**RE: Mirabal Residence, 6216 Camino Alto NW
Grading and Drainage Plan
Engineers Stamp Date 6/6/14 (D10D003B1)**

Project Title: MIRABAL RESIDENCE Building Permit #: _____ City Drainage #: D10-D003B1

RE: **Mirabal Residence**
Grading and Drainage Plan
Engineers Stamp Date 5/08/14 (D10-D003B1)

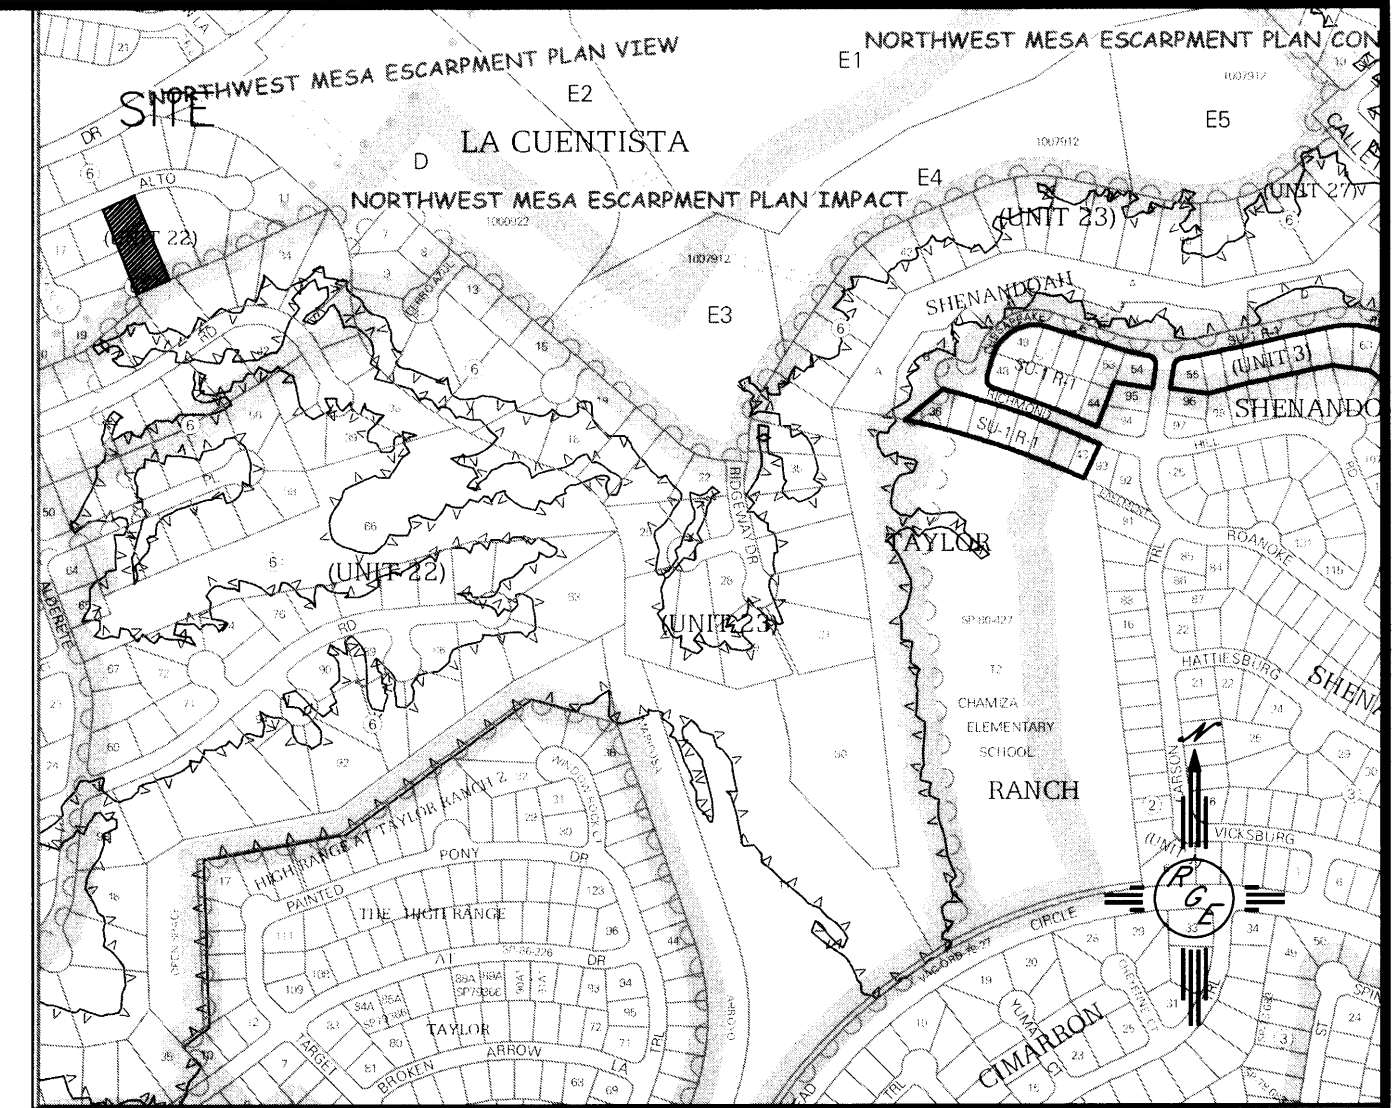
- The ponds and infrastructure need to be certified.
- There is one lot specified on the plans but four addresses given on the sheet. Is this lot being built for 4 homes? ✓
- Build notes are needed. ✓
- Label the proposed contours and differentiate between each contour in the legend. ✓
- This lot is in two different basins. Quantify these flows for pond 7 since Basin 207 is allowed to free flow south. ✓
- How is the remainder of basin 207, to the east of this lot, allowed to discharge? It appears that basin 207 will be blocked with the screen wall. ✓
- The solid black line in the middle of the home, is this a retaining wall? ✓
- Existing contours around the site are difficult to read. ✓
- It appears that flows are headed towards the home in the middle of this site.
- Two elevation spots on the west of the driveway are 5305, they do not appear to be correct?

5. Site has two basin, quantify
The attached spread sheet and exhibit show
6. allow upland basin 207 to enter site
We have provided turned blocks to allow upland flow

7. clarify solid black line interior of house
We have called out the step in slab
8. existing contours difficult to read
We have darken the lines to help
9. correct flow heading towards house near middle
I correctly showed a 2' stem extends past step in house, the provides for flow away from house.

10. elevation of 5305 at west side of driveway appear incorrect
The mislabeled spots were corrected
